Your Ref: OWPC21688
Our Ref: WA/7/19/RES
Please ask for:
Stuart Corbey

Approval of reserved matters following outline consent WA/26/18/OUT for layout & scale for 6 No. dwellings & 6 No. detached garages.
Lanes End West Walberton Lane Walberton

Walberton Parish Council objection to WA/7/19/RES.

PJ DEVELOPMENTS LTD 2 Square Chambers 23 High Street Emsworth PO10 7AQ Tel: 0843 289 3430 Email: enquiries@pjdevelopmentsltd.com	
PROJECT: FORMER LANES END	
SITE PLAN OUTLINE PLANNING APPLICATION	
DATE: JANUARY 2019	DWG. NO 19-001 PL02
SCALE @ A1: 1:200	
REV: C

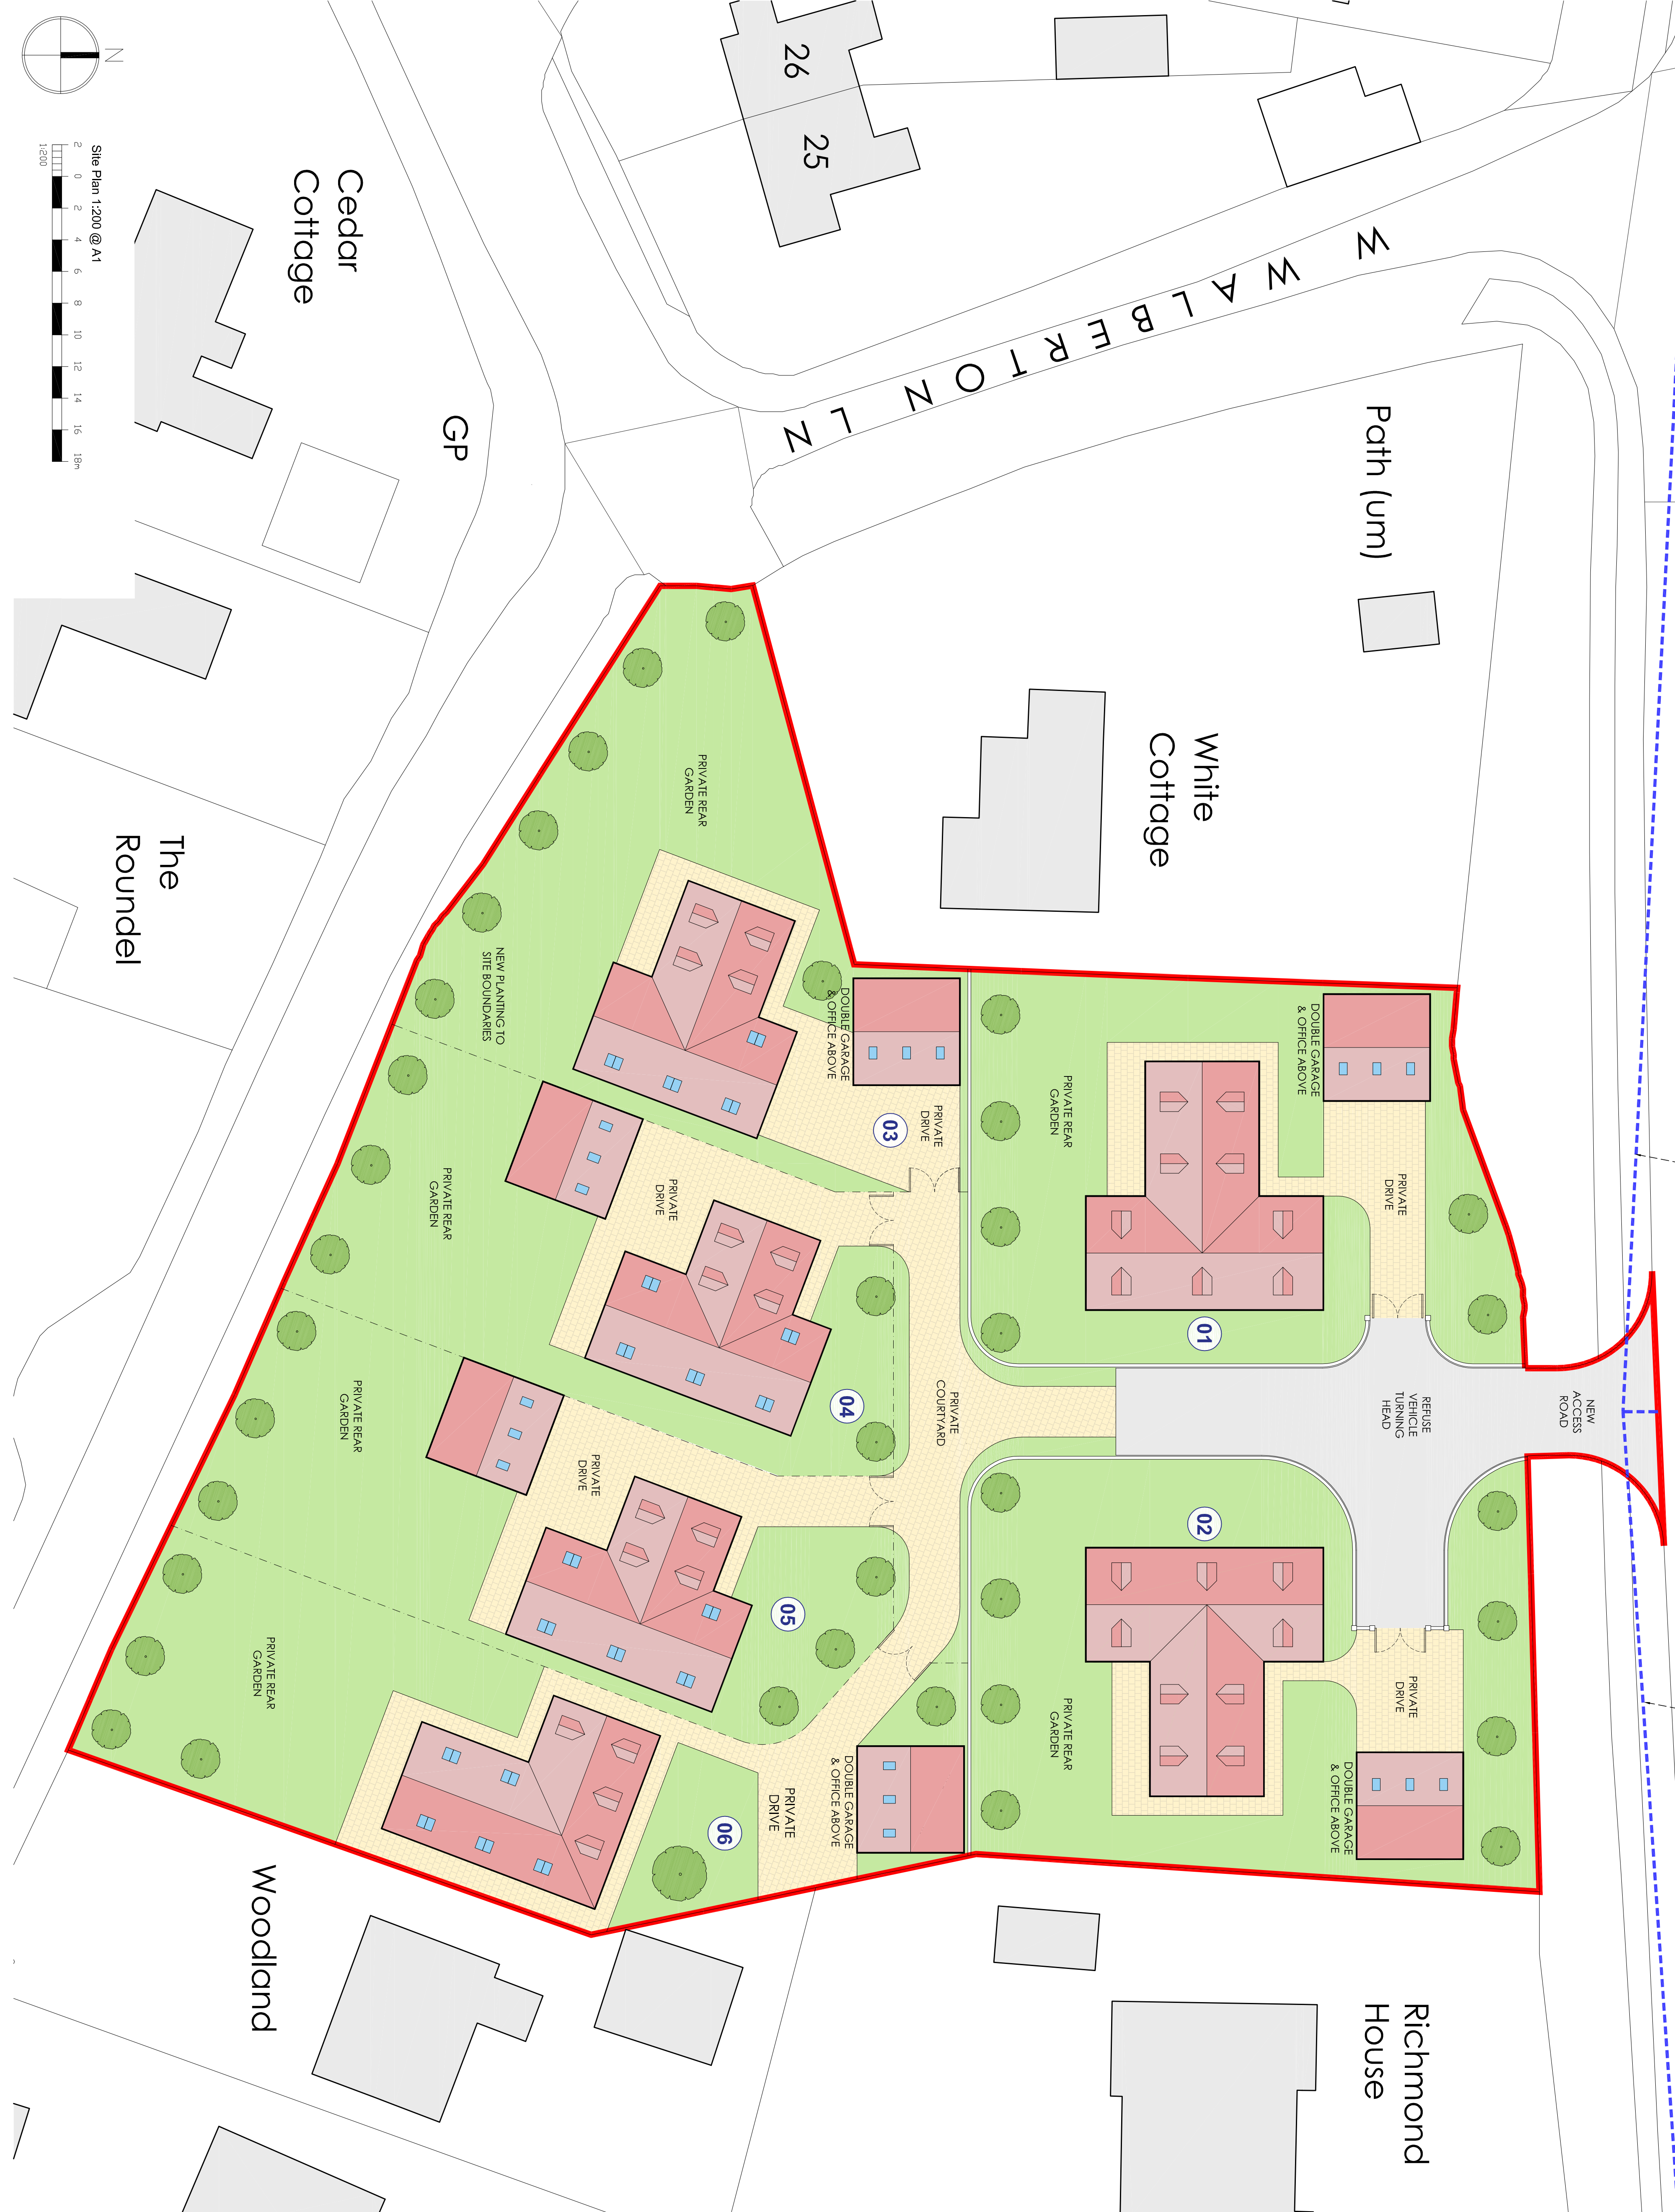
The Applicant has stated that all mature trees on the boundary would be kept yet none of these trees are shown on the layout document in the application. This does question the accuracy of the layout plans within the application and/or the intention to remove trees before an appropriate survey has been completed.

PLOTS 1 AND 2 FLOOR PLANS AND ELEVATIONS

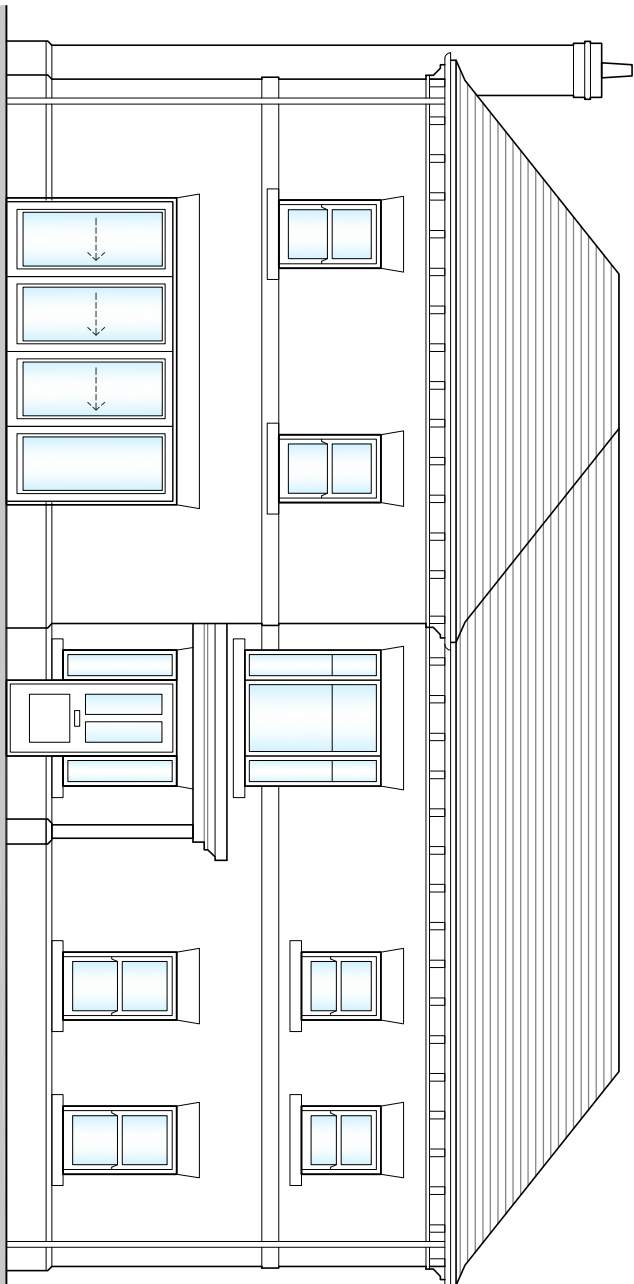
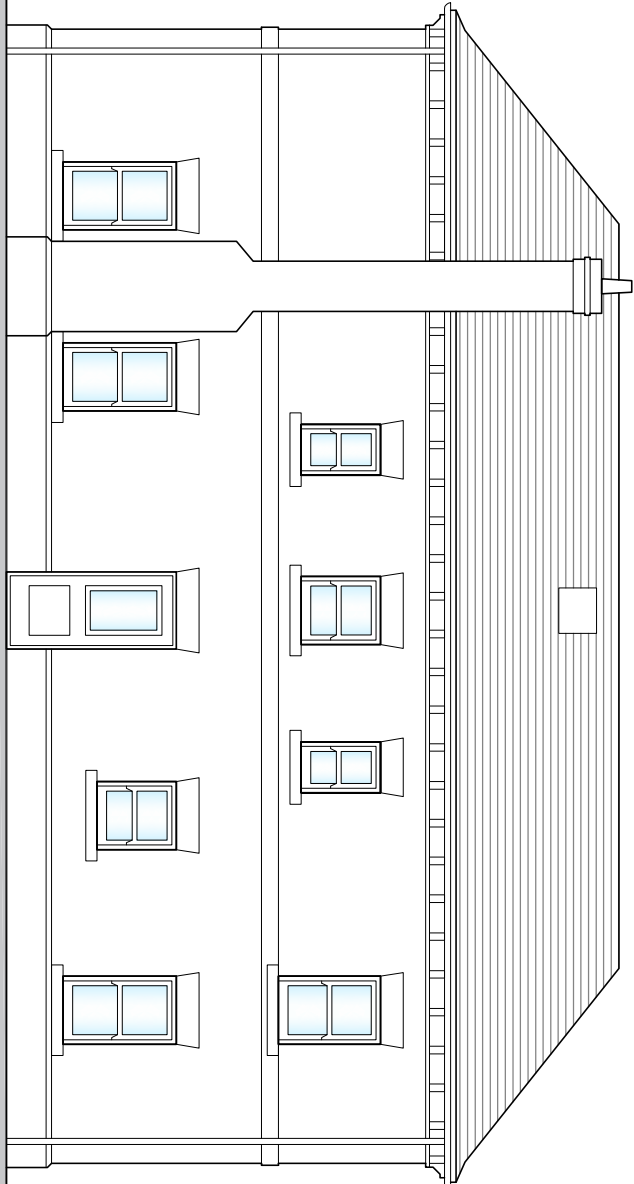
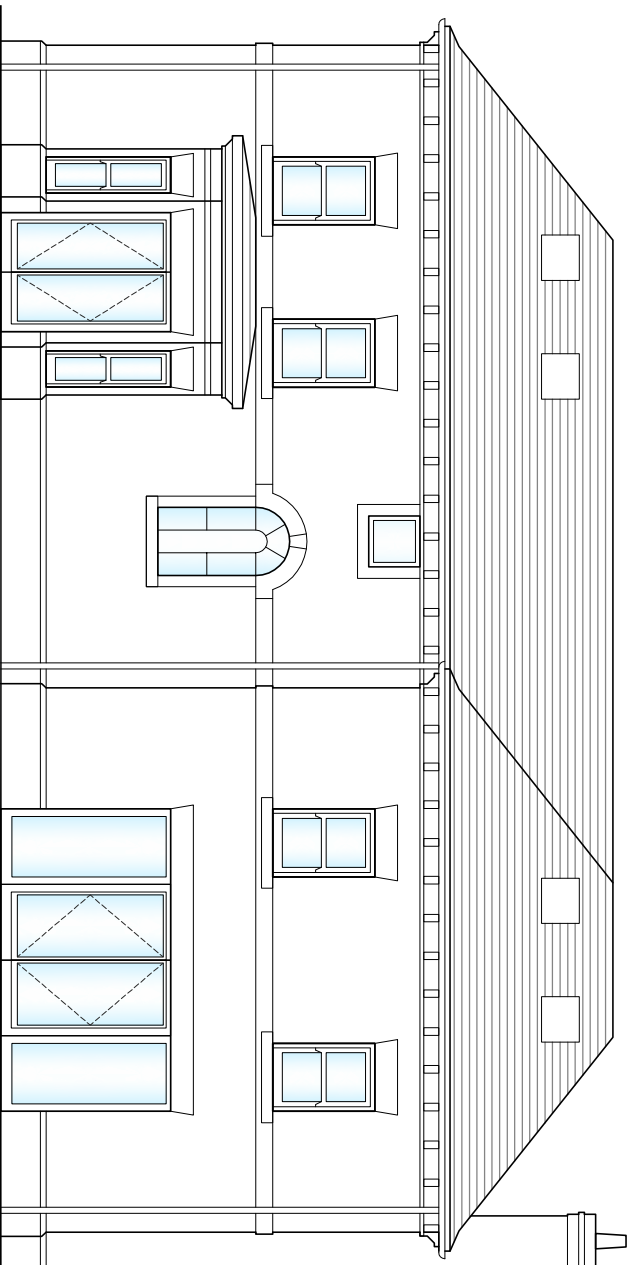
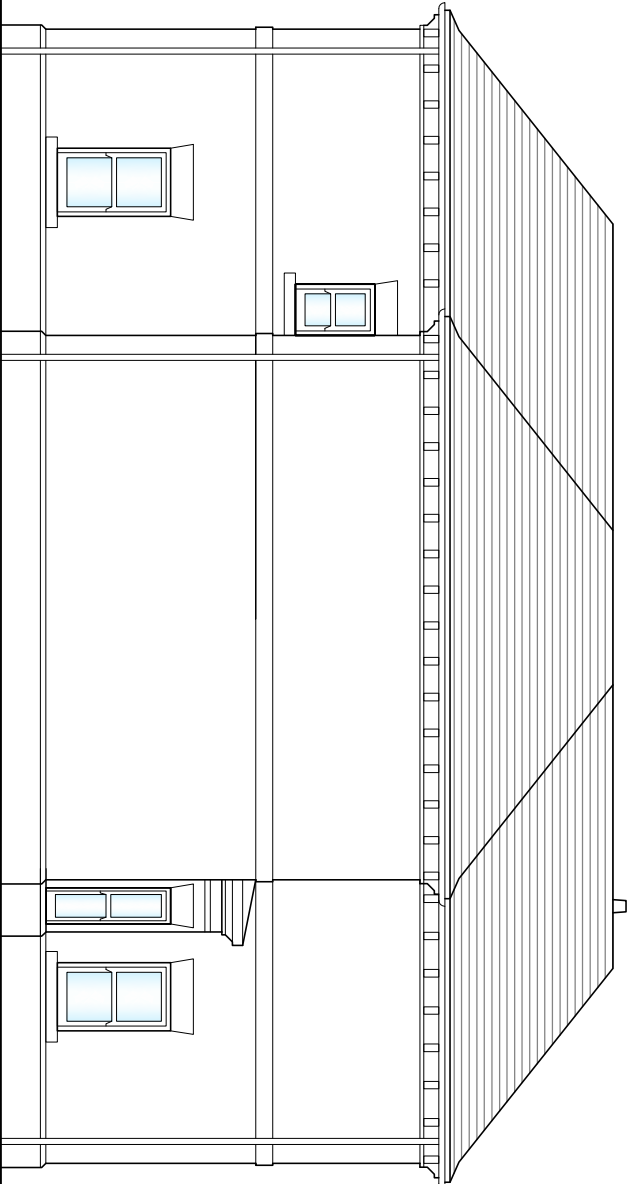
Section 12 para 130 of the NPPF states that 'Permission should be refused for development of poor design that fails to take the opportunities available for improving the character and quality of an area and the way it functions,...'. The Council should ensure that, even though this development will significantly increase the density of the site, it should be designed with sympathy to the local character and landscape as Section 12 paragraph 127 states. The proposal for 6 homes of 2.5 storeys is out of character for the

locality which is predominantly bungalows and 2 storey homes, along both West Walberton Lane and Arundel Road. Lower ridge heights would be more in keeping with the locality.
